Planning Services

Sign Permit Review Form

HIGHLAND GROVE PHASE I

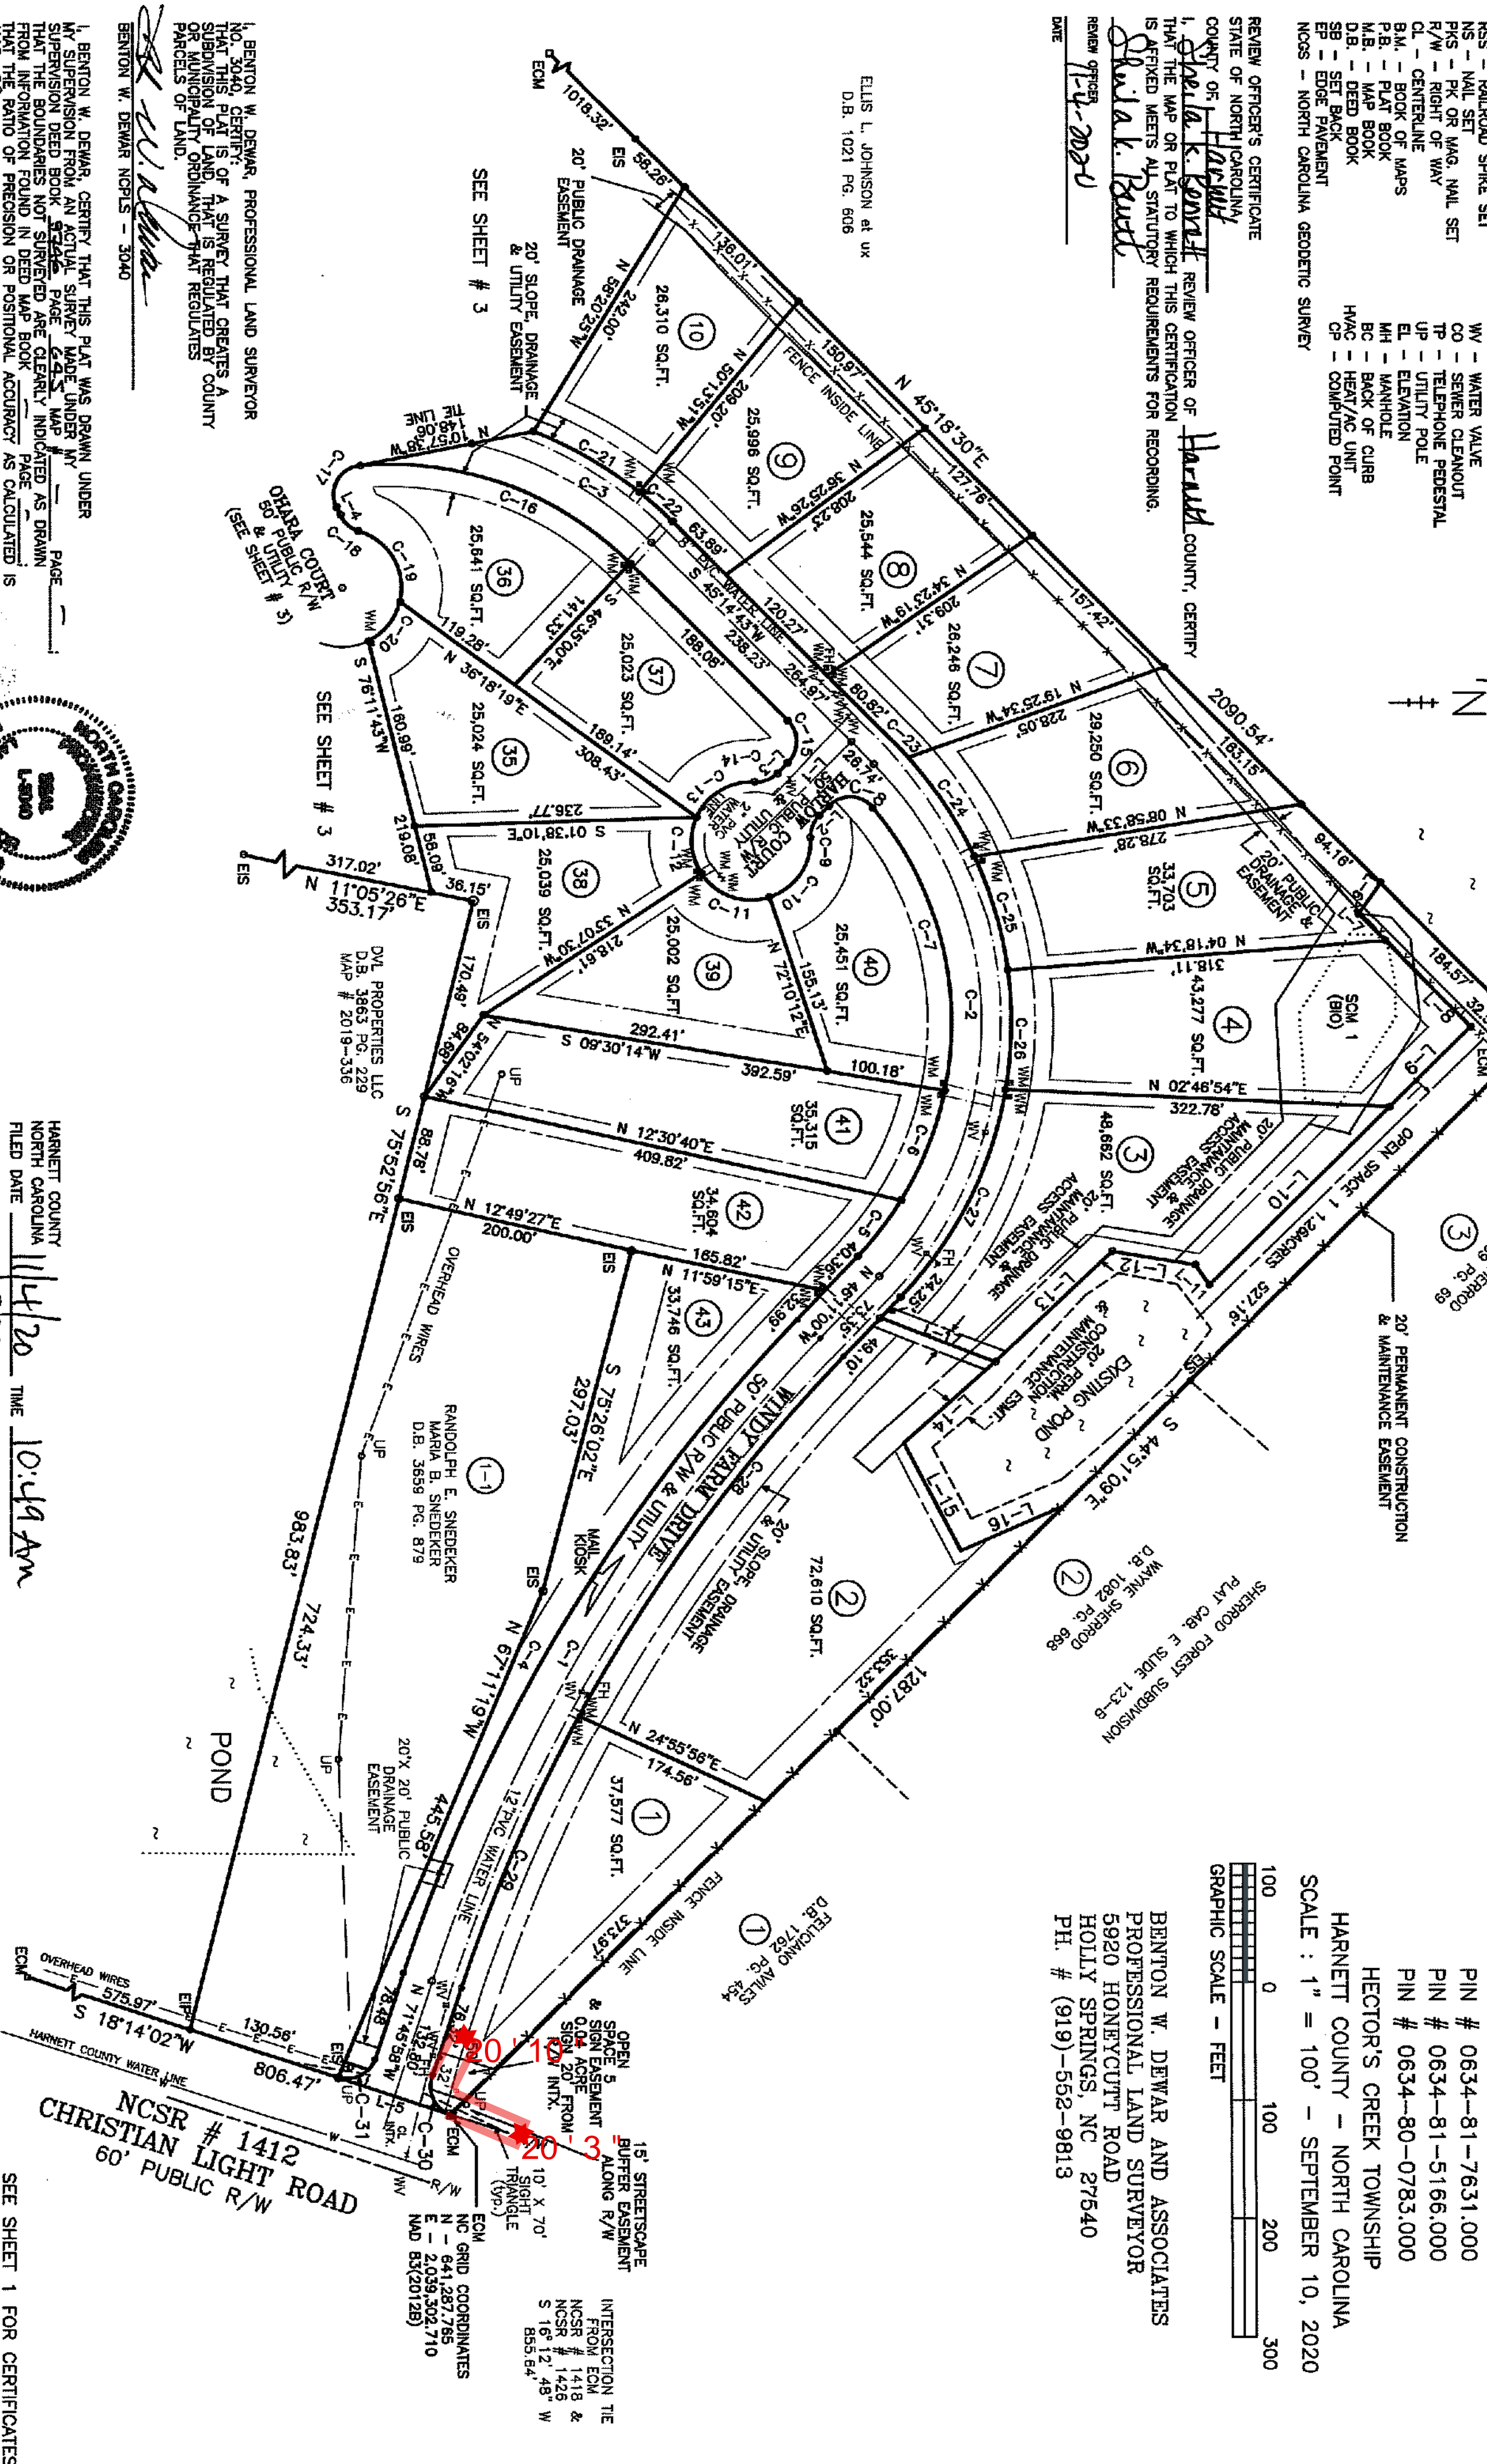
2. Sign should be located within sign easement.
3. Please provide a PIN # for the property on the applications submitted. The PIN number should be for the property with the sign easement.
4. Indicate the distance between the sign and each R/W.

No sign may be located in, or overhang into, any public right-of-way except as permitted and erected by the North Carolina Department of Transportation. Signs that are located within public right(s)-of way shall be constructed to meet NC DOT standards. Signs shall be set back at least 10 feet from any public right(s)-of-way line or property line. In cases where signs are placed at intersections, the minimum setback shall be 20 feet as measured from each right-of-way line or property line in both directions, except those erected for orderly traffic control and other municipal and governmental purposes.
